RE: **McDonald's - Old Town MRP**
2305 Central Avenue NW
Lot 5-B, Block 2, Traction Park Addition

File # **J13/D053**

Grading & Drainage Plan for Grading /Building Permit **PE Stamp: 11/25/13**

Based upon the information provided in your submittal received 12/16/2013, the above referenced plan cannot be approved for **Building Permit**.

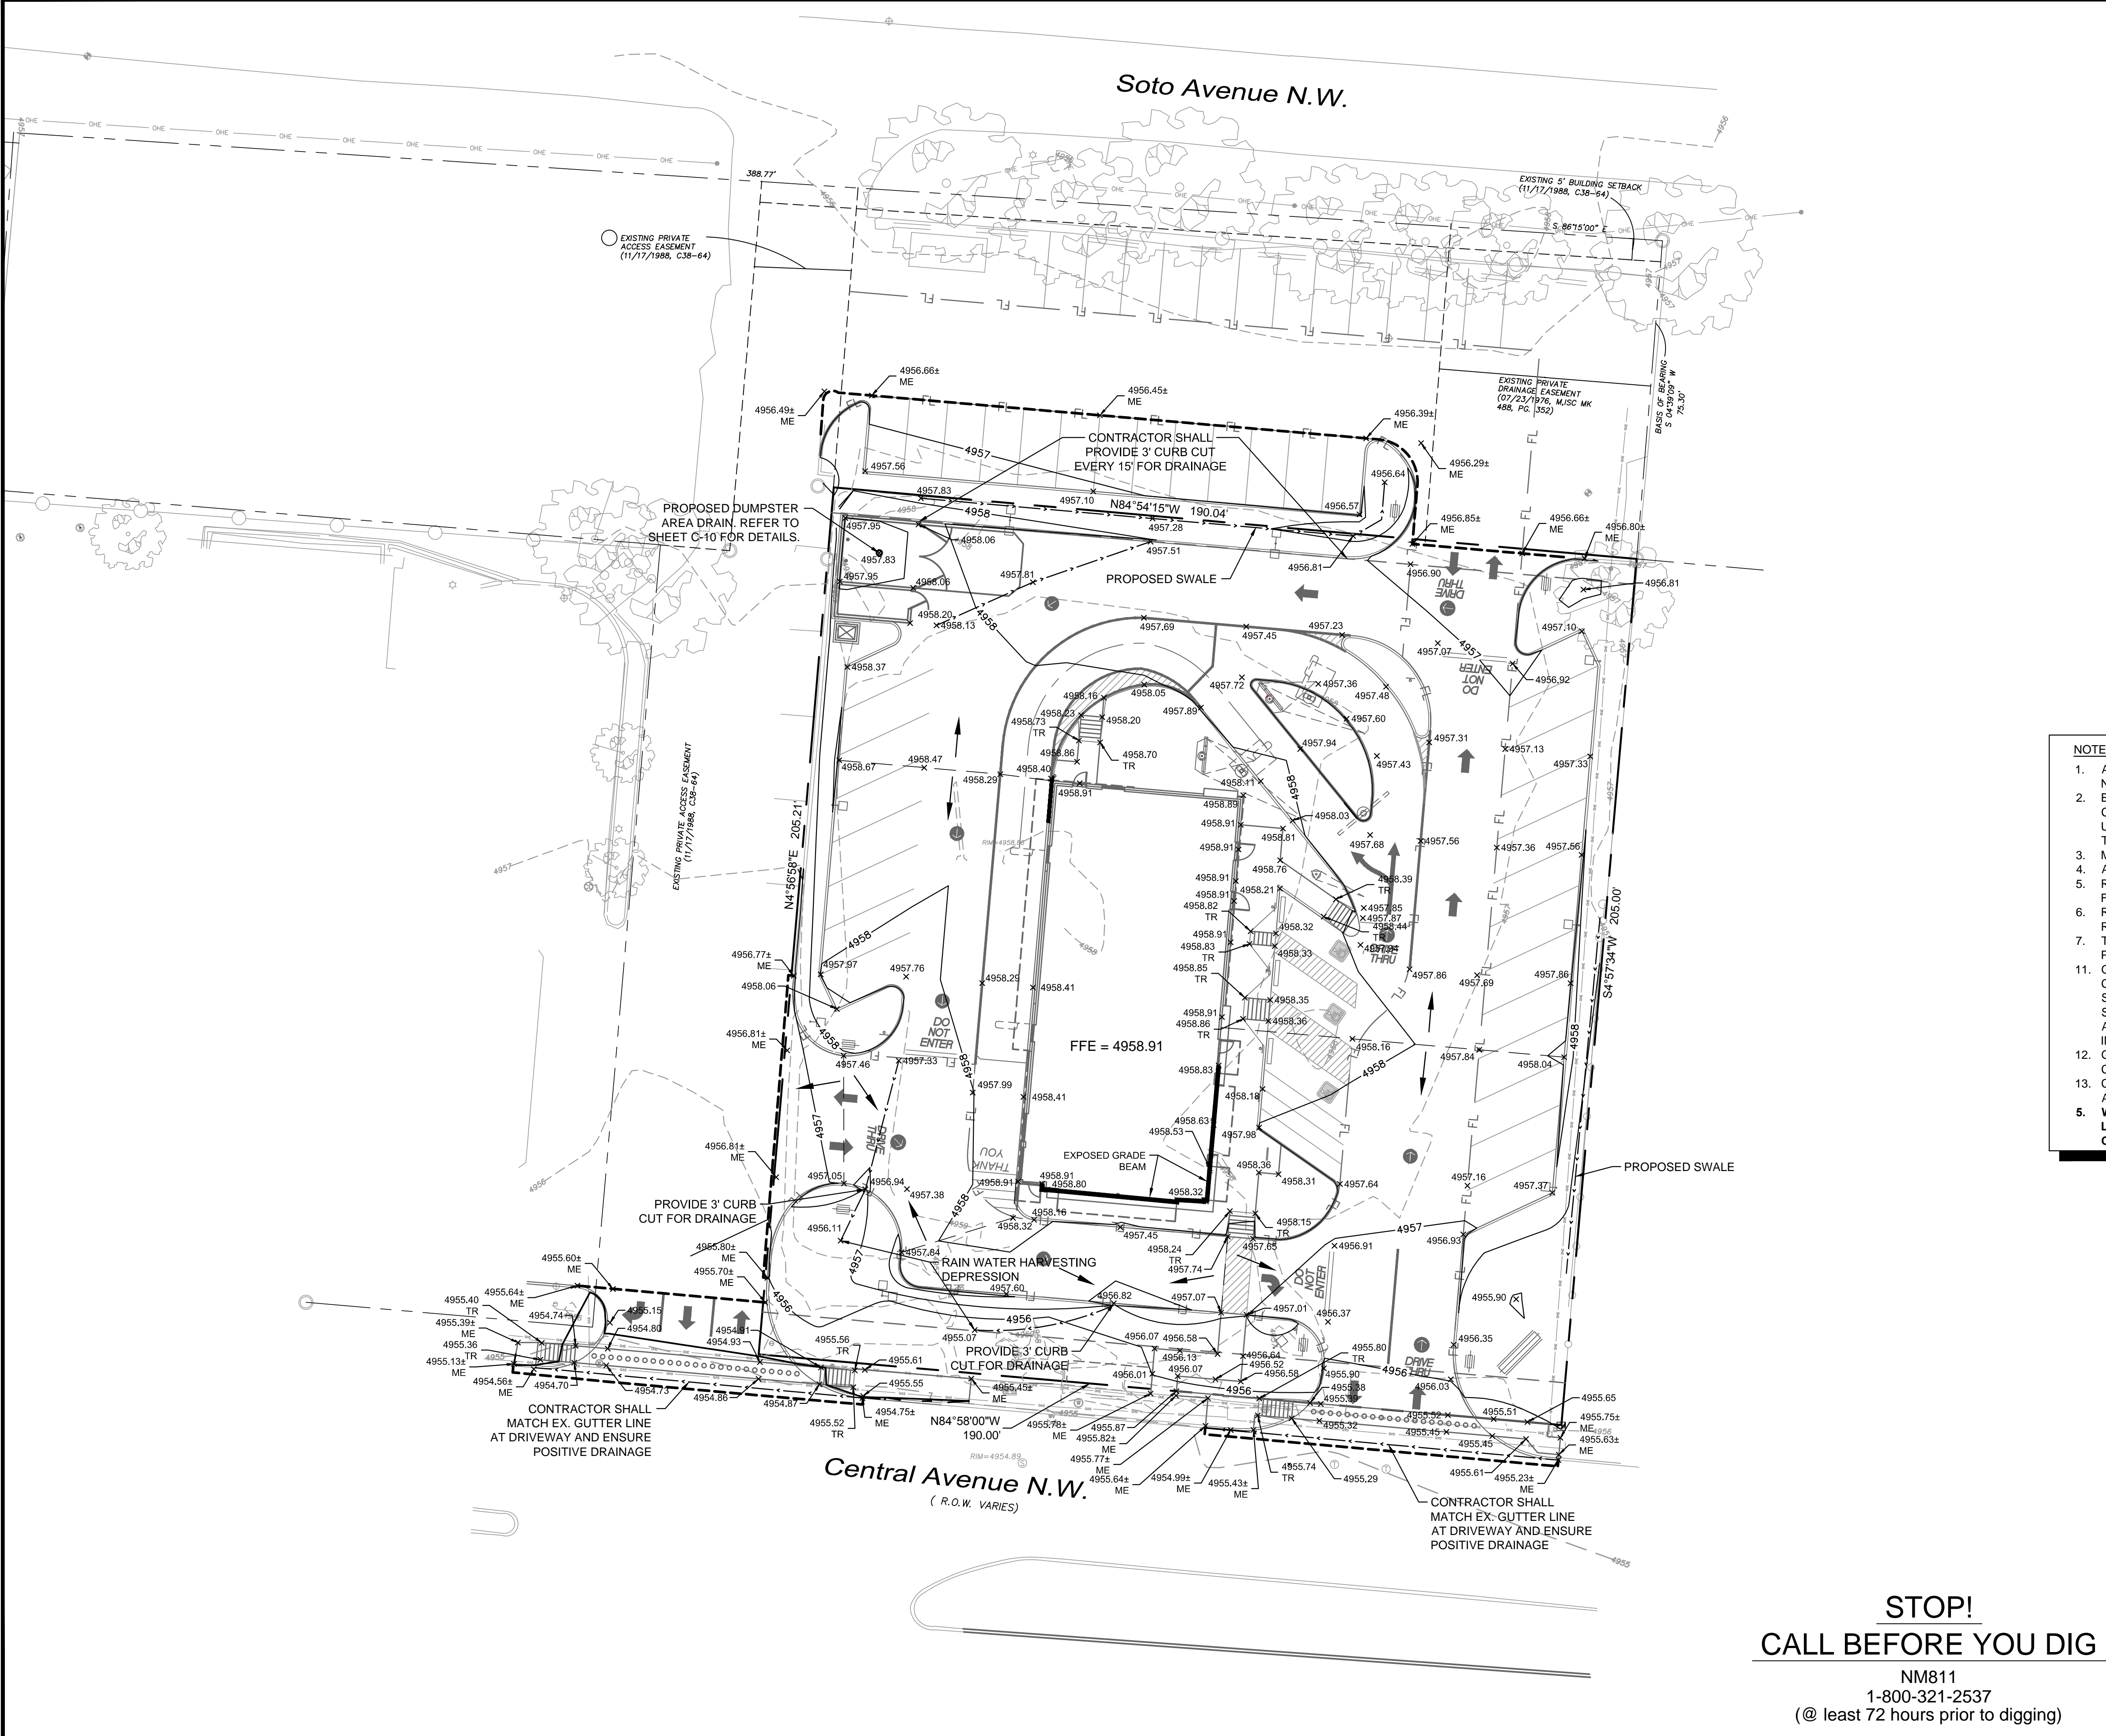
2. The Drainage submittal should include runoff computations for the existing and proposed conditions on this site. Runoff must be at or below historic rates for the 100-year, 6-hour storm event. *[Note: Calculations on file, from Chavez-Grieves Consulting Engineers in 1994, indicate the developed Q_{360} rates on the site to be 2.23 cfs south to Central, and 1.22 cfs north to Soto Ave., via the drainage easement at the NE corner of the site.]*

3. The proposed grades and opening in the perimeter curb near the NW corner of the site will allow runoff to leave the site without dedicated downstream easement. Provide an appropriate easement, or adjust grades to direct flows to the existing easement at the NE corner of the site.

4. Per the COA Development Process Manual (DPM) Chapter 22 Section 9, runoff from the trash enclosure pad is required to drain to the sanitary sewer.

5. In effort to comply with the City's MS4 Permit from EPA, we are requesting that commercial landscape and parking island areas be depressed to harvest rainfall. This Low Impact Development (LID) feature may be integrated to divert and detain runoff at historic rates, with a side benefit of improving storm water runoff quality.

6. Label the offsite Drainage Easement on the Grading Plan (NE corner).
7. Clarify the relationship of the offsite parking and paving north of Lot 5-B to this site and the proposed Grading Plan.

8. Several locations on your plans make reference to "Call Before You Dig" with incorrect information. Check the NM One Call website at NMOneCall.org and make appropriate corrections for construction in New Mexico.

9. If landscaping rock is proposed in any detention ponds, grades should be at "top of rock" to ensure that the finished pond provides the required volume.

SHEET NO. C-3

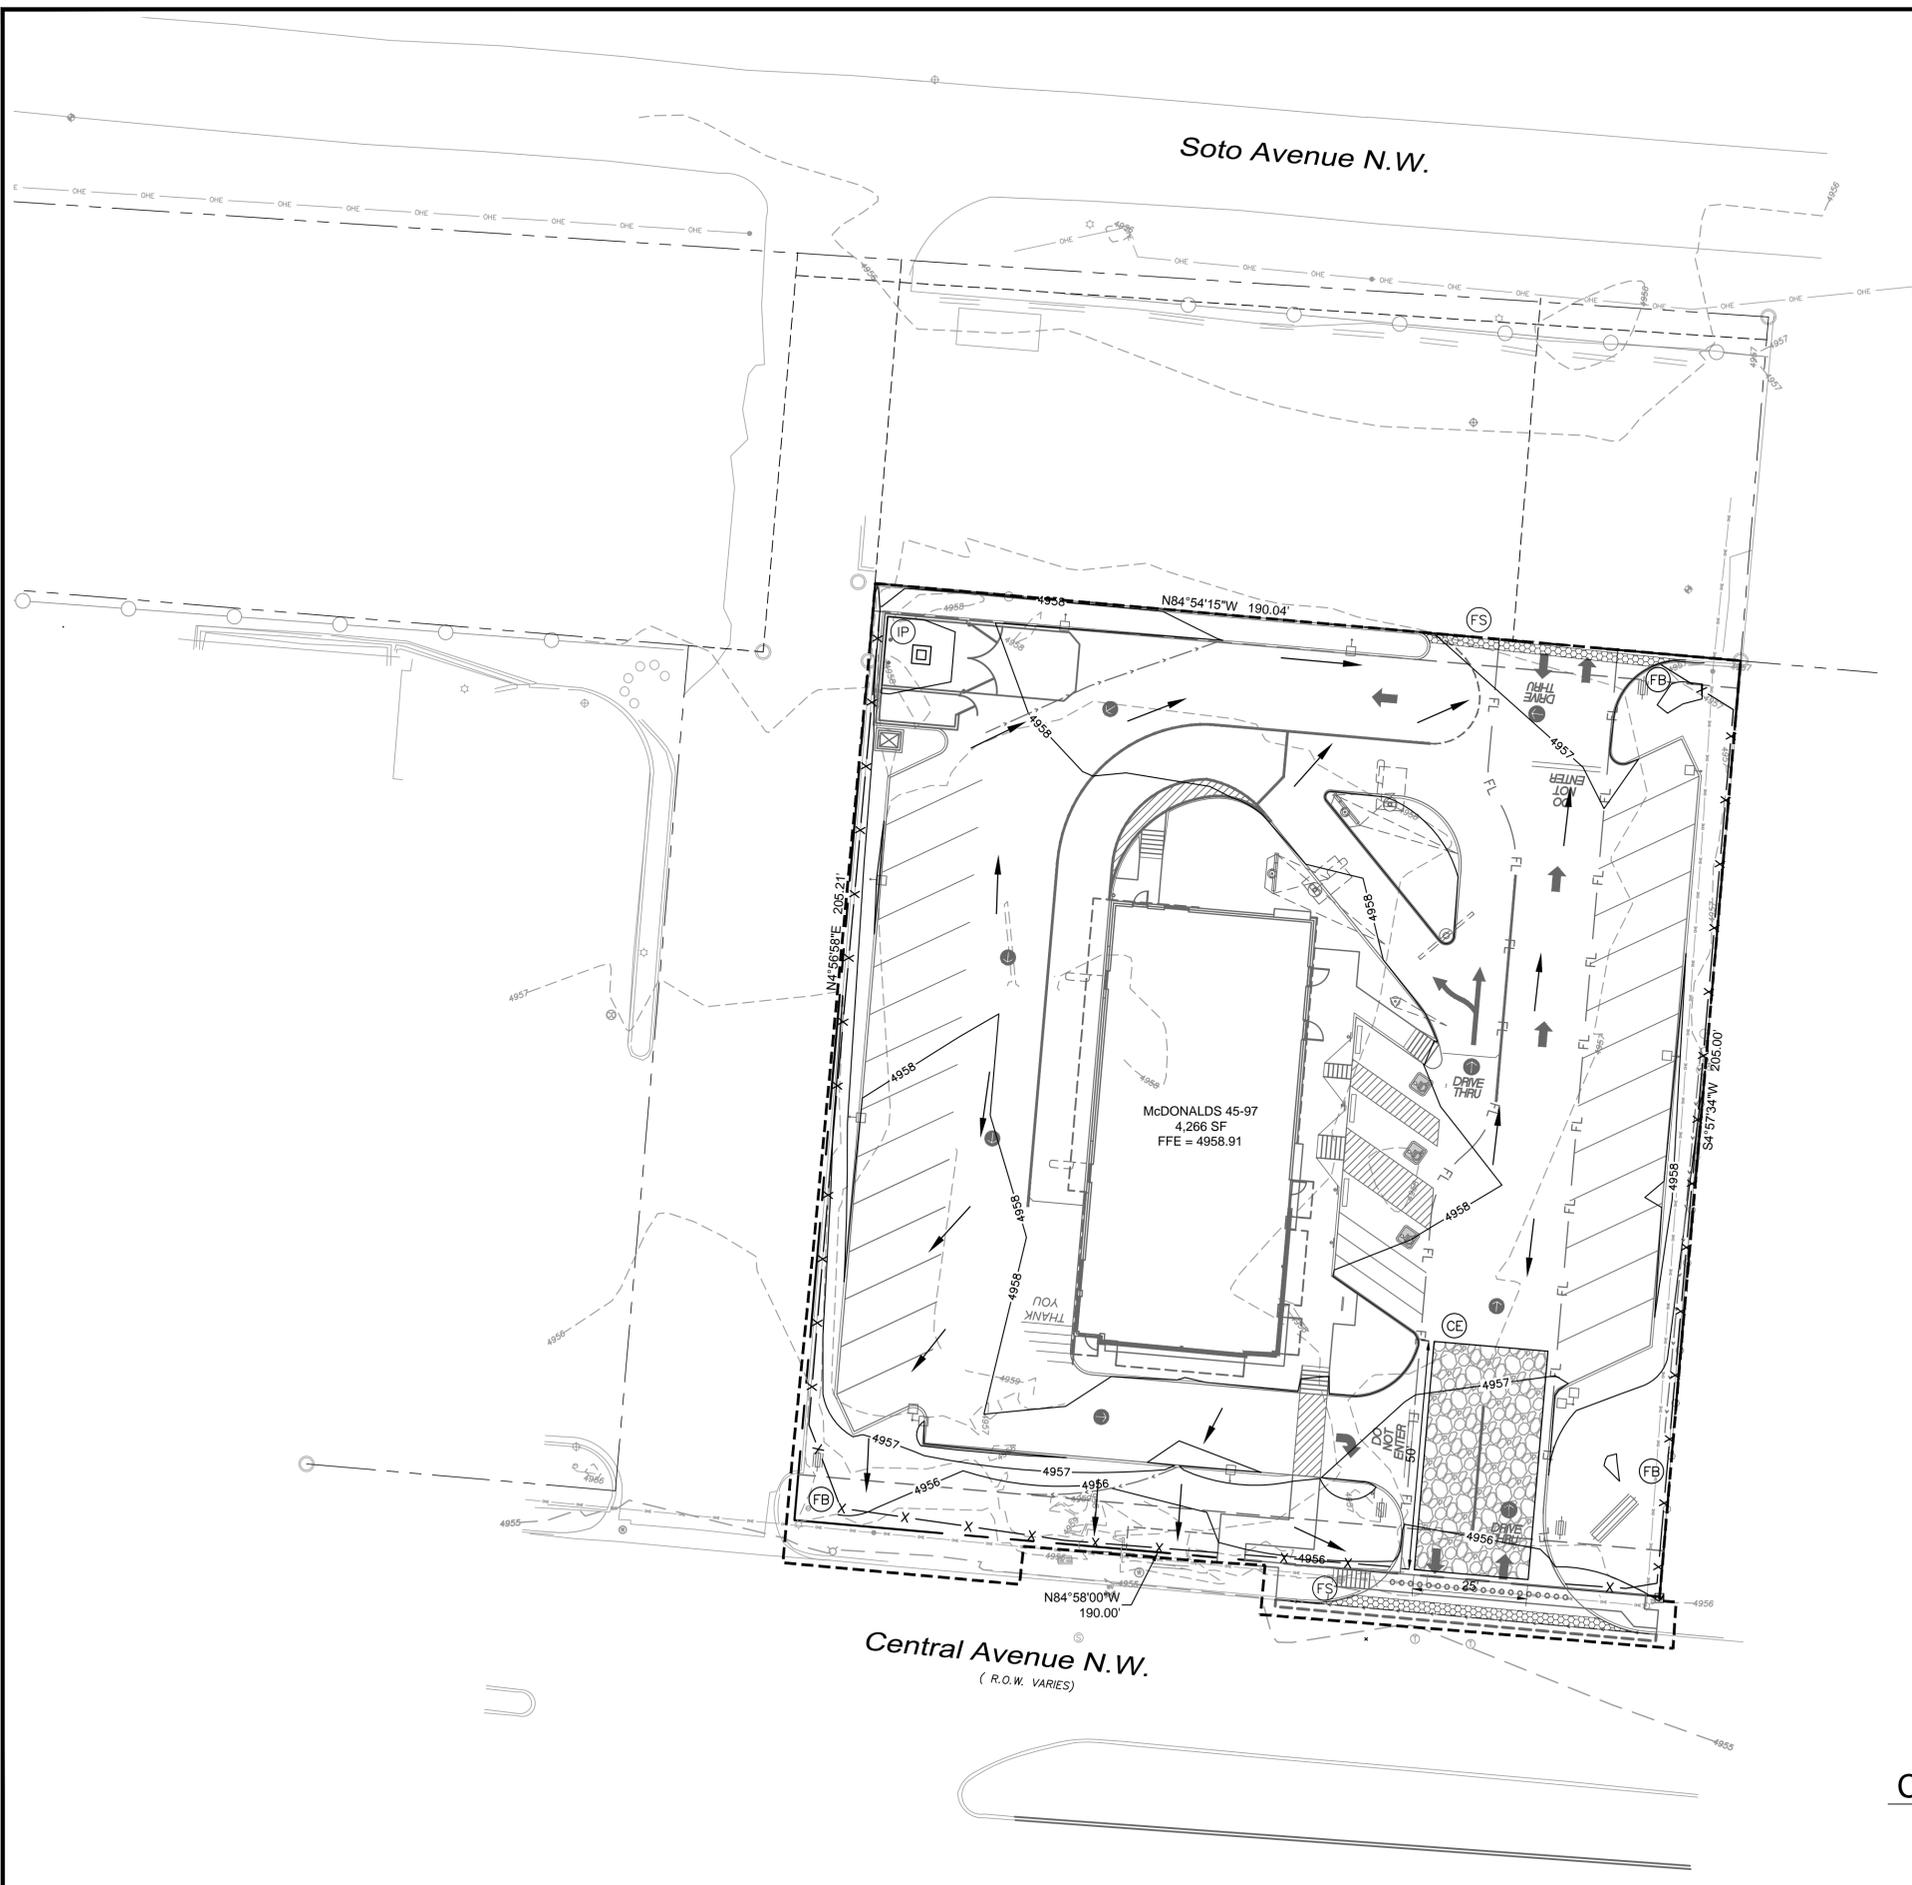
10. Per sheet C-3, this site, including the offsite parking and driveway entrance improvements, currently totals 1.0 acres of disturbed area, which is the trigger point under our MS4 Permit for requirement of an Erosion and Sediment Control (ESC) Plan, sealed by an NM PE. This plan needs to be submitted separately, for review by the Storm Water Quality Engineer. Since you included an ESC Plan in this submittal, I am offering the following notes:

- a. The Plan calls for Filter Sock (FS) at two locations, but provides no detail for this BMP.
 - b. Gaps in the perimeter Filter Barrier (FB) appear to allow alternate, construction access points without the benefit of BMPs to avoid sediment off-tracking.

- c. There are disturbed/construction areas outside of the Filter Barrier. Clarify how construction ESC will be provided in these areas.
